From: [REDACTED]
Sent: 25 September 2026 16:13
To: Susan Haley
Cc: [REDACTED]
Subject: RE: K/20/26/HH - Panorama, Golden Acre, BN16 1QP
Attachments: BN16 1QP_500_Existing location plan.pdf; BN16 1QP_501_Existing block plan REV3.pdf; BN16 1QP_502_Proposed block plan.pdf

I have begun reviewing application K/20/26/HH - Panorama, Golden Acre, BN16 1QP and noticed the existing location and block plan, and the proposed block plan, appear to require amendment. Following a site visit and a review of Google Earth, I have attached a visual example to illustrate the discrepancies.

02 BLOCK PLAN
Scale 1:500

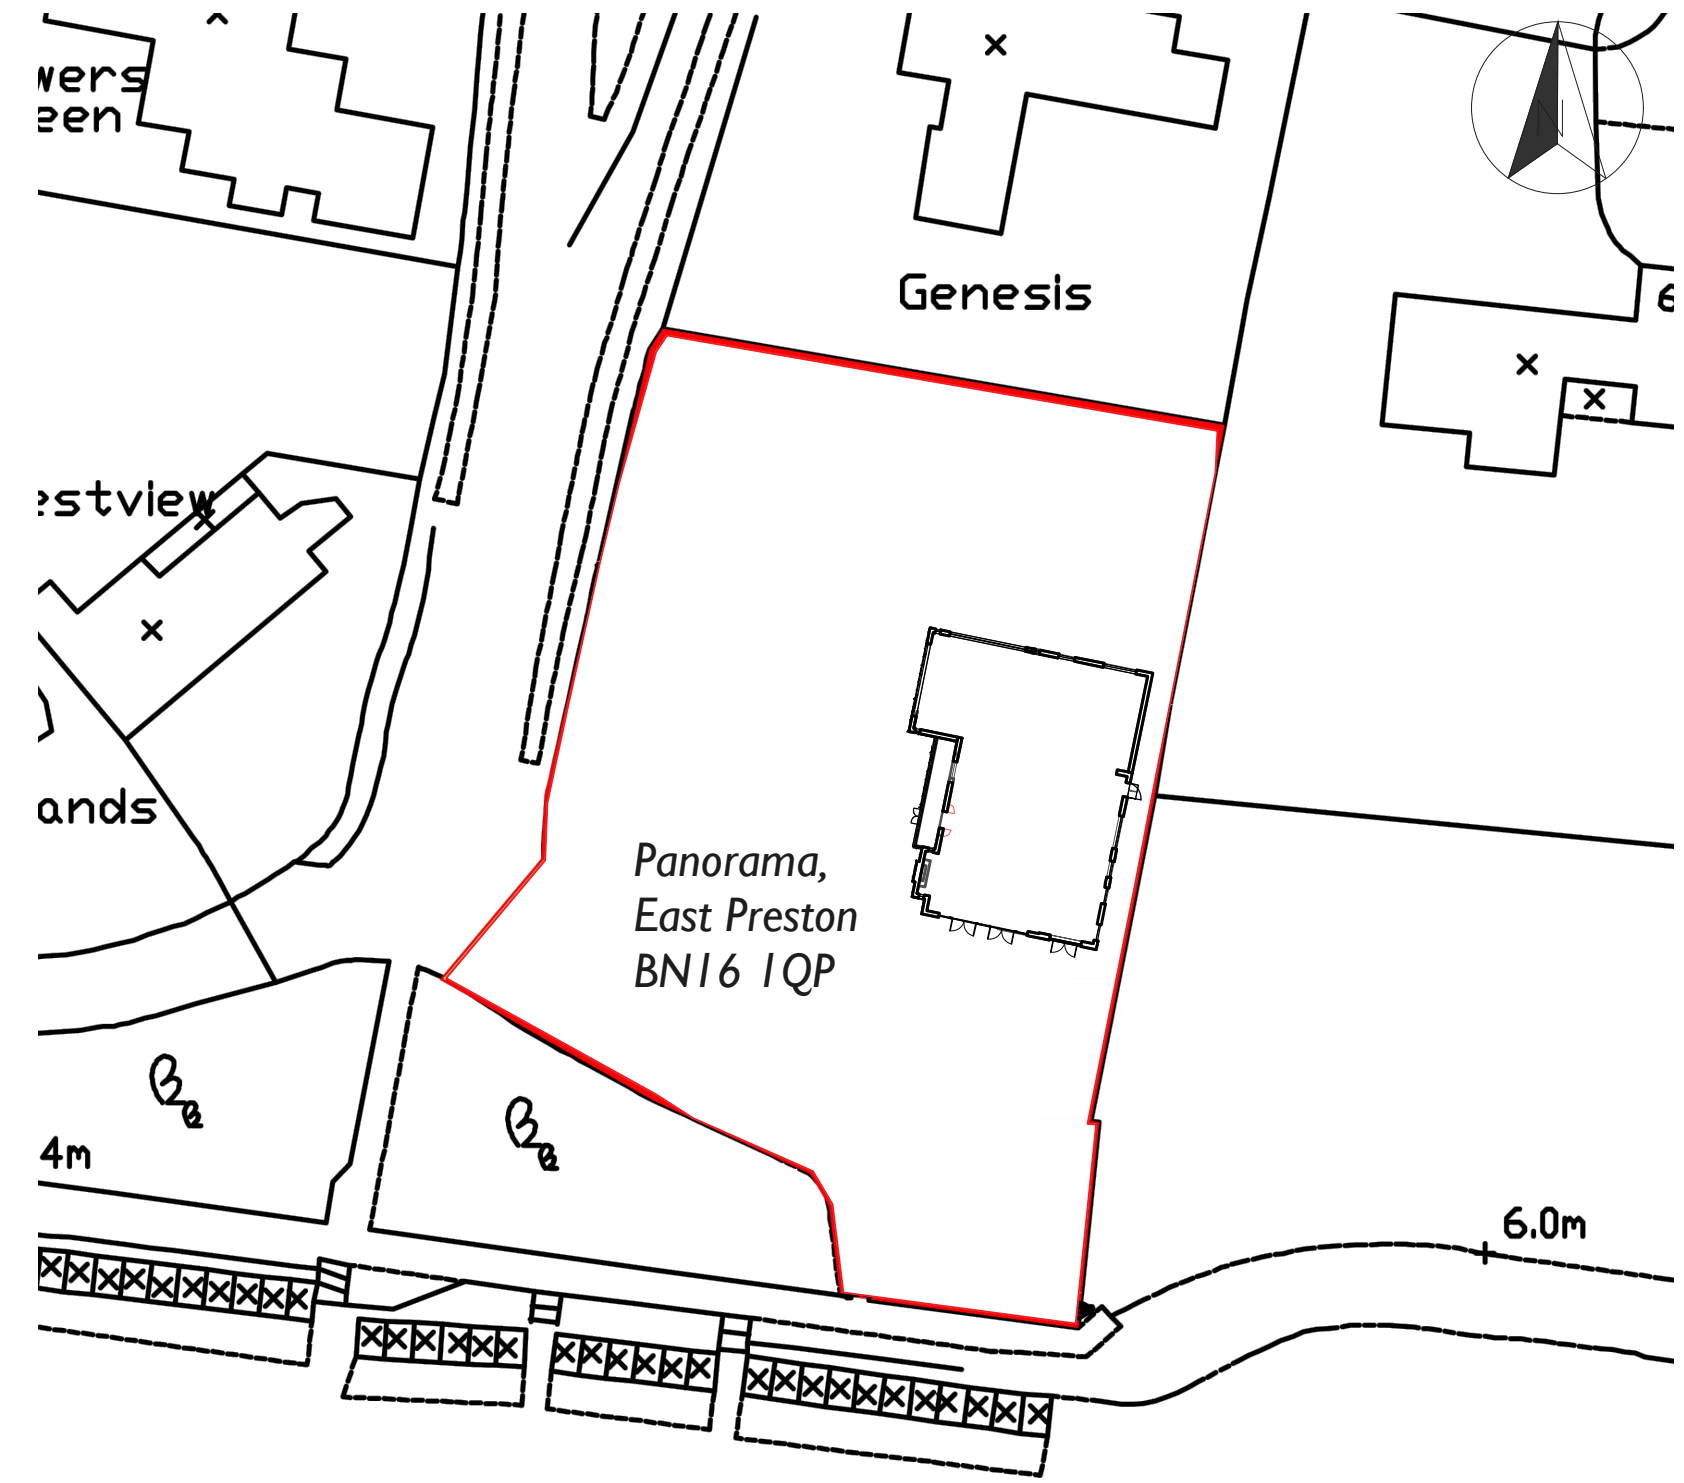
For the existing location and block plan (Drg. No. 500), the neighbouring garage to the north is not shown. For the proposed block plan (Drg. No. 502), the existing wall does not appear to extend to the rear boundary as it appears to from the site visit and Google Earth imagery. It also appears that the

proposed garage would extend significantly beyond the neighbouring garage; further than indicated on the block plan.

I understand that the previous drawings sent were not accurate, thank you for pointing this out. Please see the updated drawings:
